## KITTTITAS COUNTY COMMUNITY DEVELOPMENT SERVICES

Subject: Shoreline Exemption Permit (SX-20-00002) - Request for Additional Information

SITE PLAN

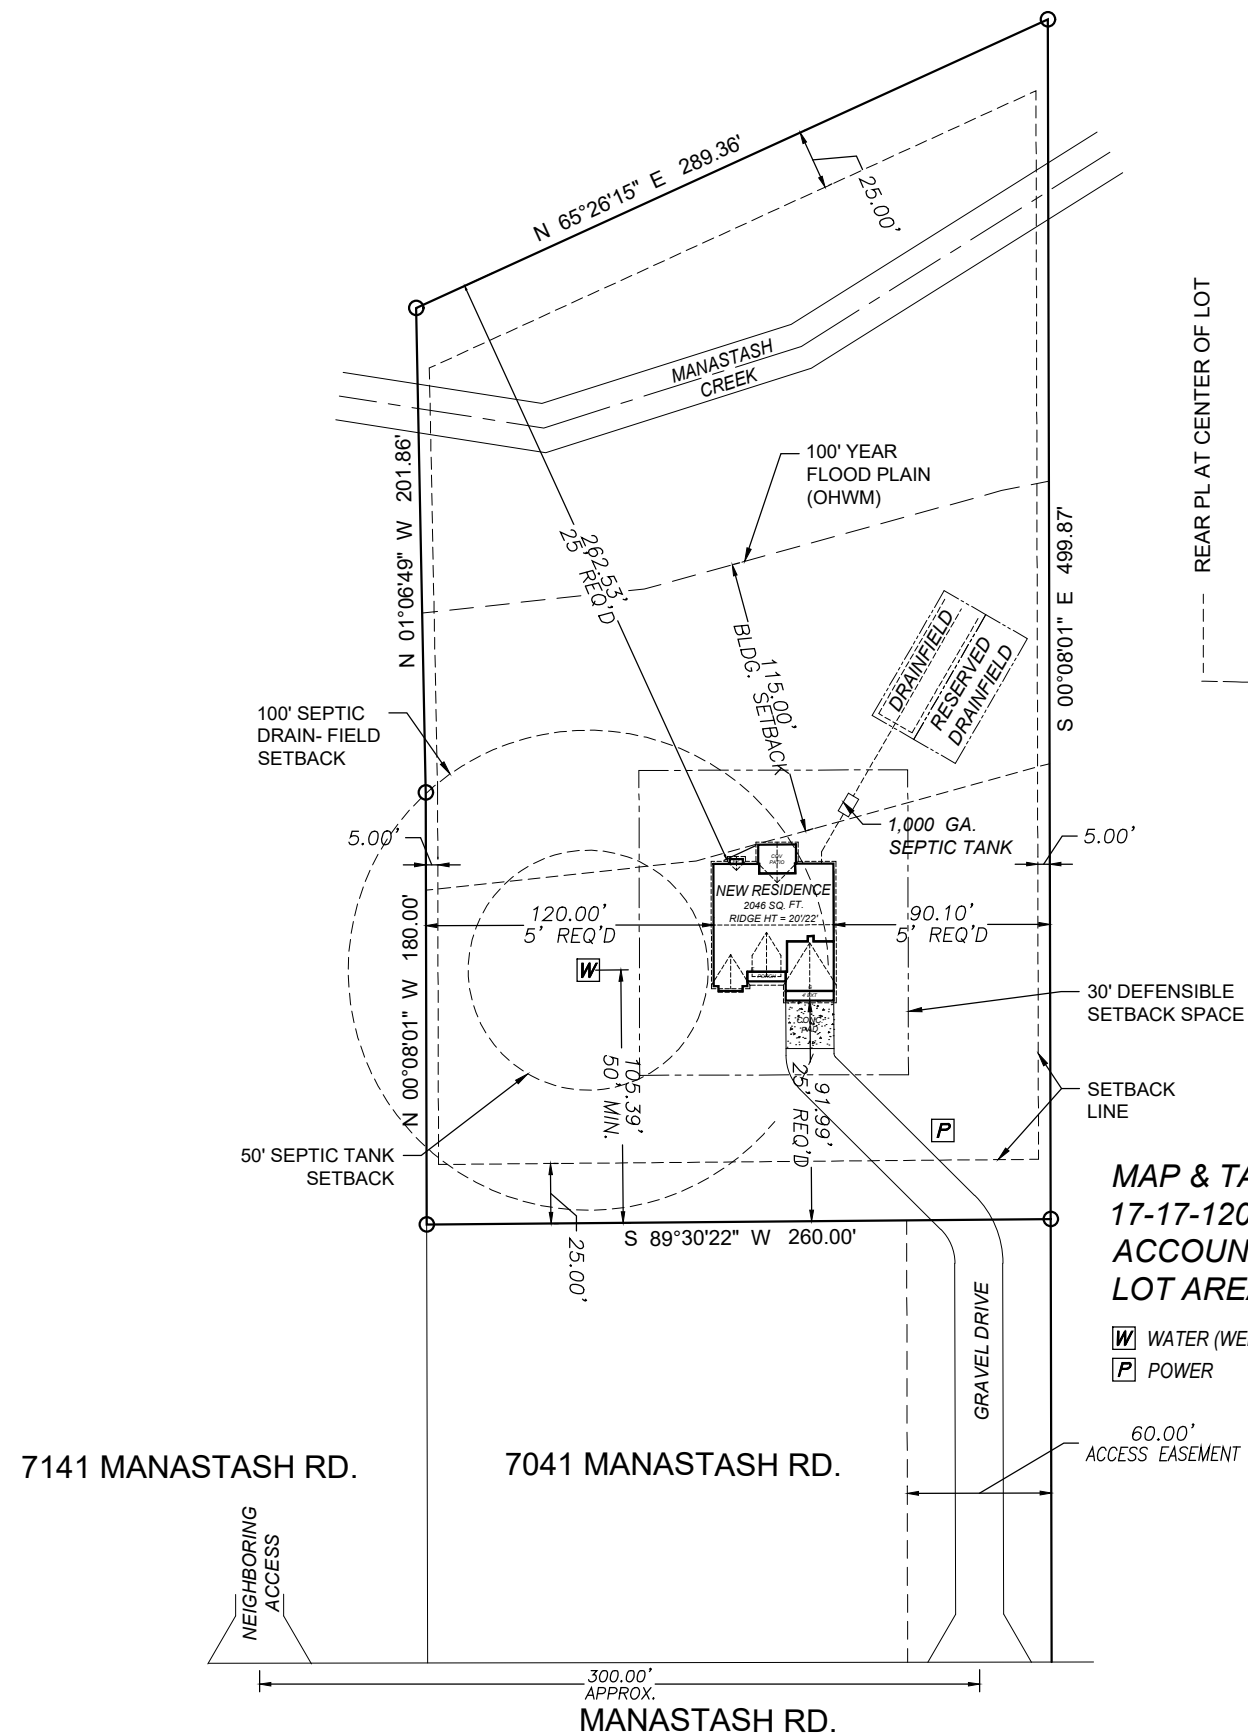
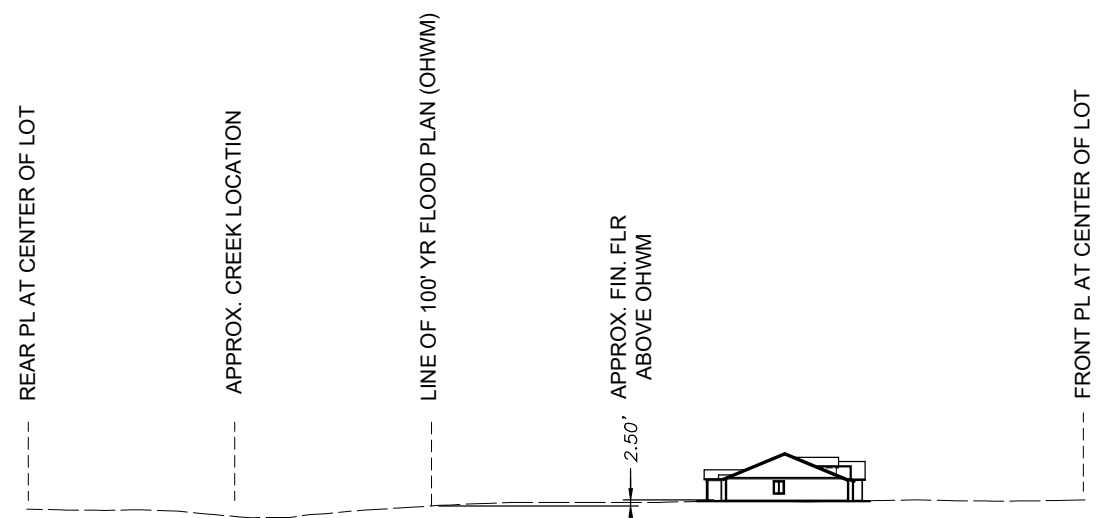
1. Updated site plan: The site plan provided does not depict the location of the identified critical areas, nor the associated buffers. The following need to be shown on your site plan:
  - a. Ordinary High Water Mark (OHWM) of the Manastash Creek
  - b. The 115' construction setback from the OHWM or the distance from the proposed structure to the OHWM.
  - c. A profile view showing the distance from the OHWM to the edge of structure/activity.

Please update your site plan accordingly.
